Application for a non-material amendment following a grant of planning permission.

<input type="text" value="Not yet approved"/>
<input type="text" value="Conversion of side garage and extend flush to front elevation, and a single storey extension to the rear."/>
Reference number: <input type="text" value="21/03575/HOUSE"/>

6. Non-Material Amendment(s) Sought

Proposed Rear Elevations
Amendment

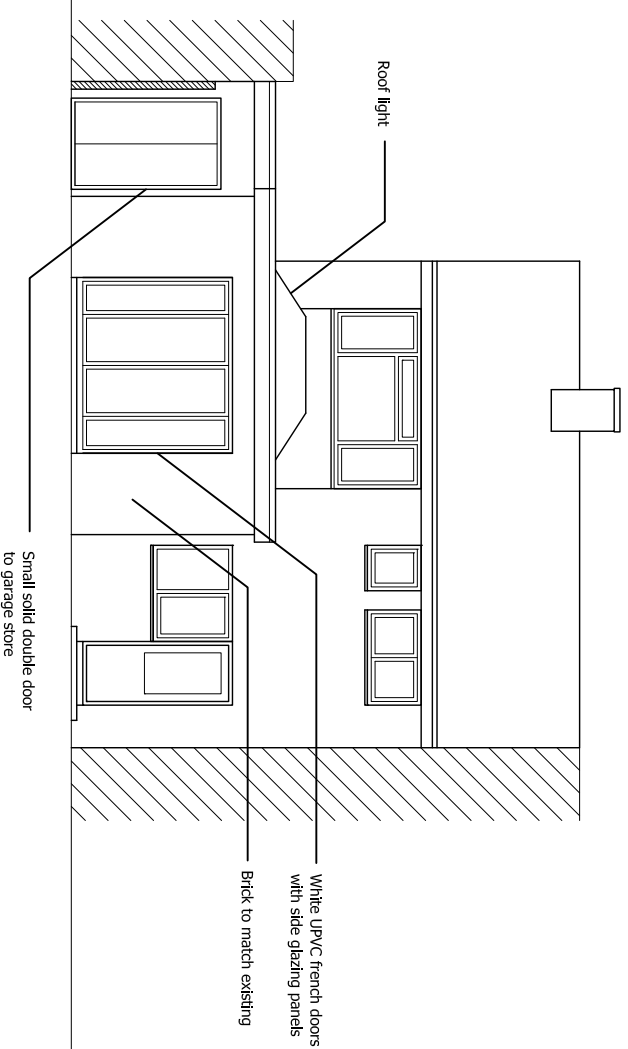
Amend the application for white uPVC Bifold doors to white uPVC french doors
